From: Paul Cann
Sent: 01 February 2018 16:35
To: Planning.Responses
Subject: RE: Planning Consultation on: AL/5/18/RES

APPLICATION **AL/5/18/RES**

Site Address: Woodgate Farm Westergate Street Westergate PO20 3SS

Description of Works: Approval of reserved matters following outline consent
AL/75/14/OUT for 2 No. dwellings.

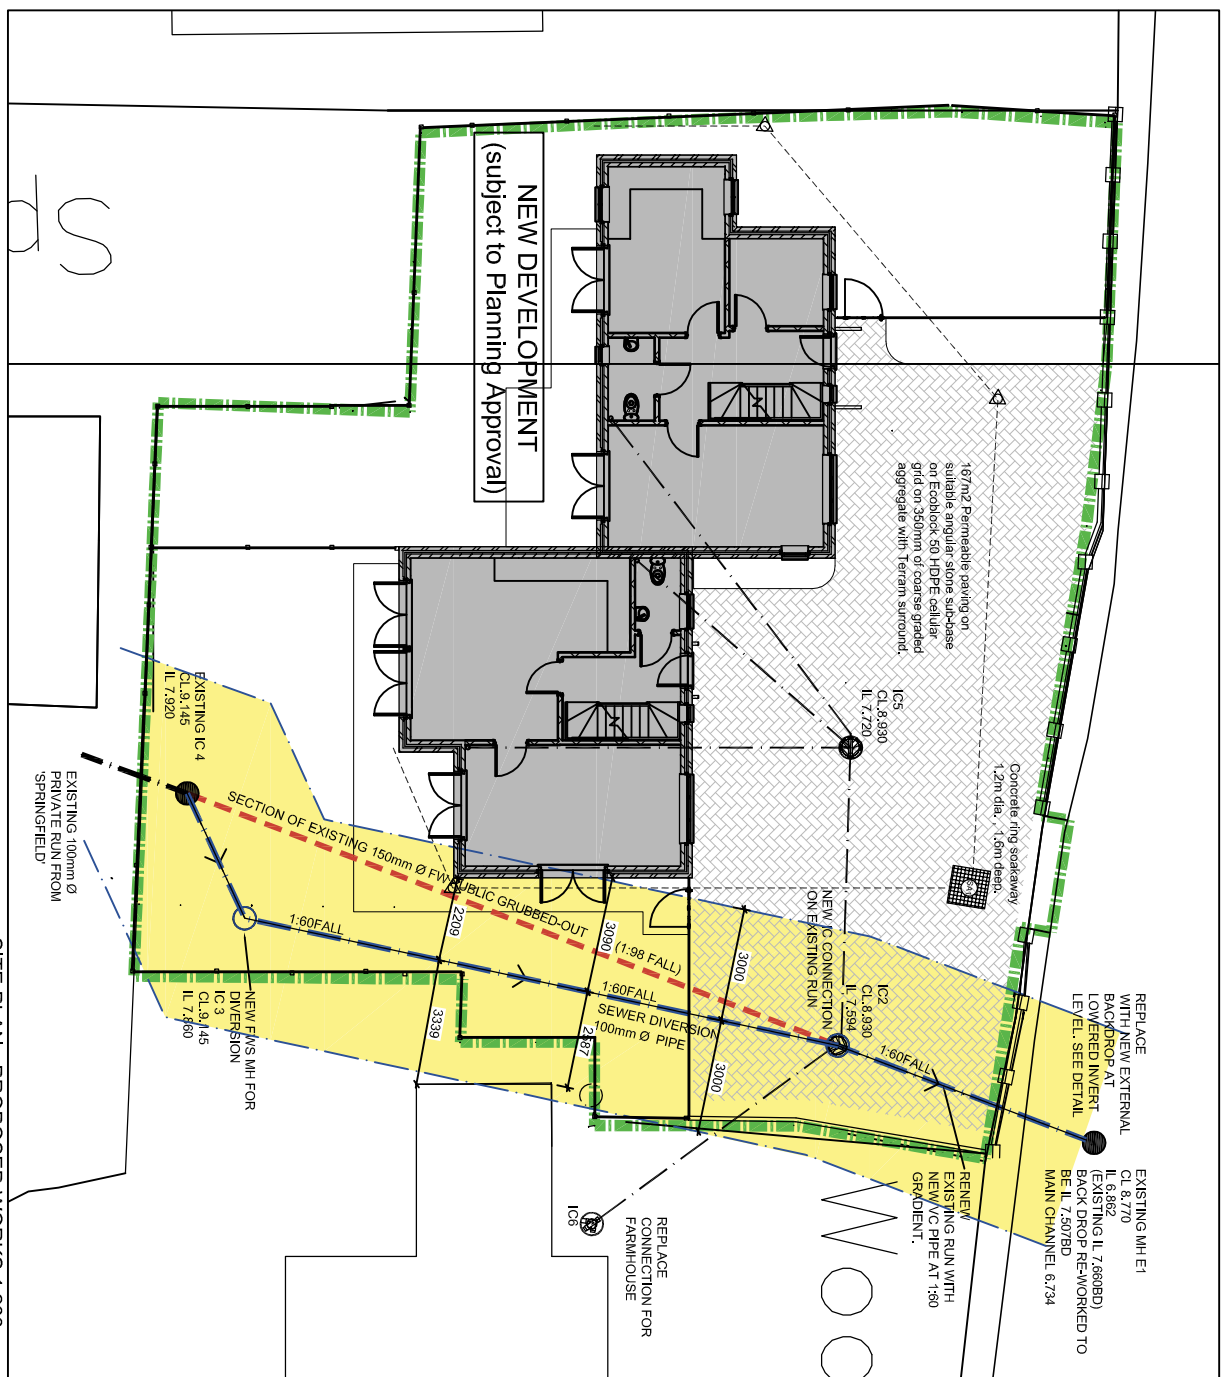
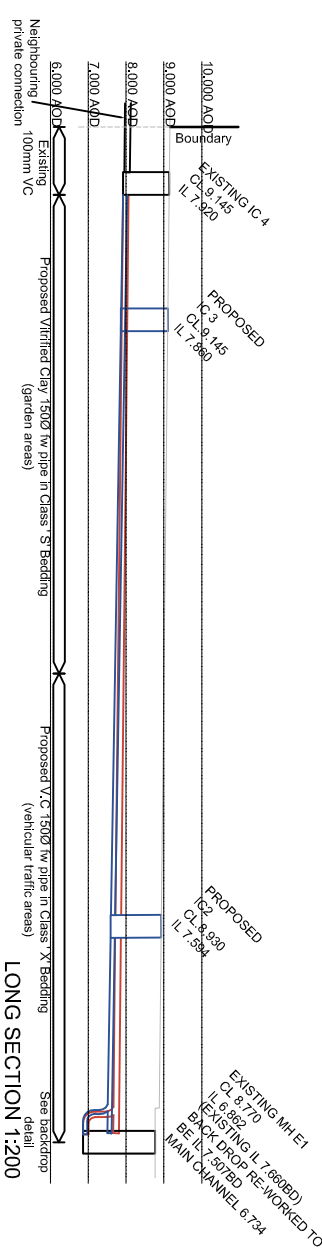
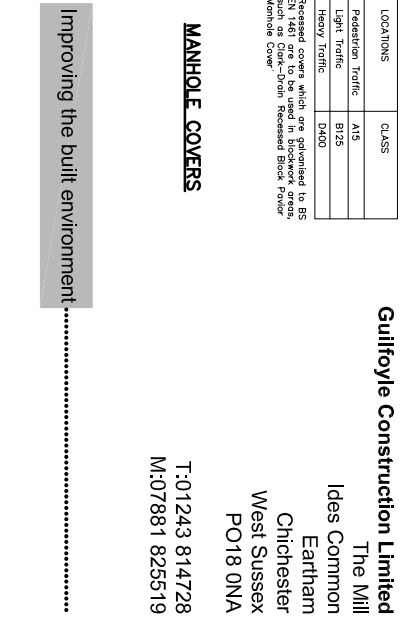
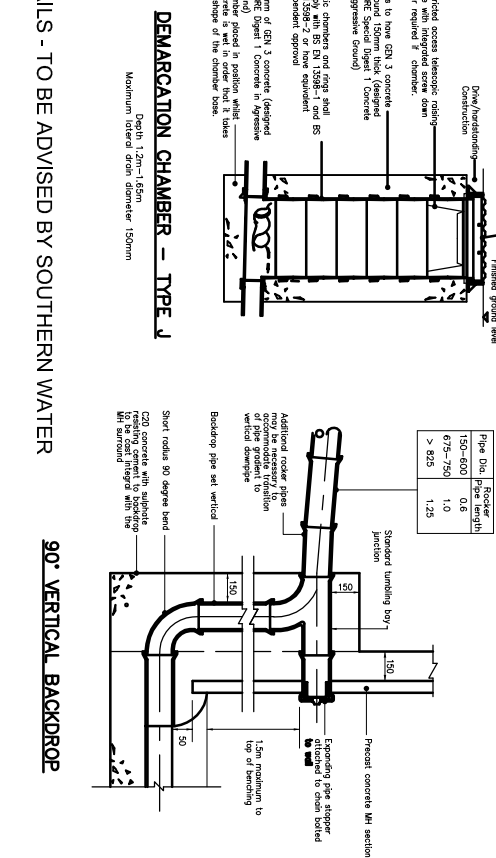
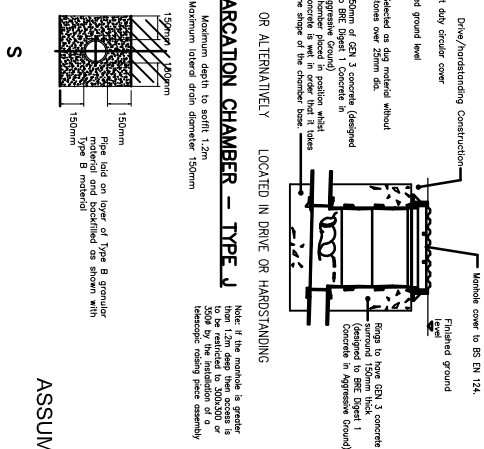
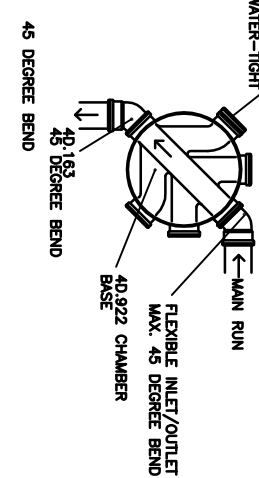
Please consult Southern Water in respect to the foul sewer diversion.
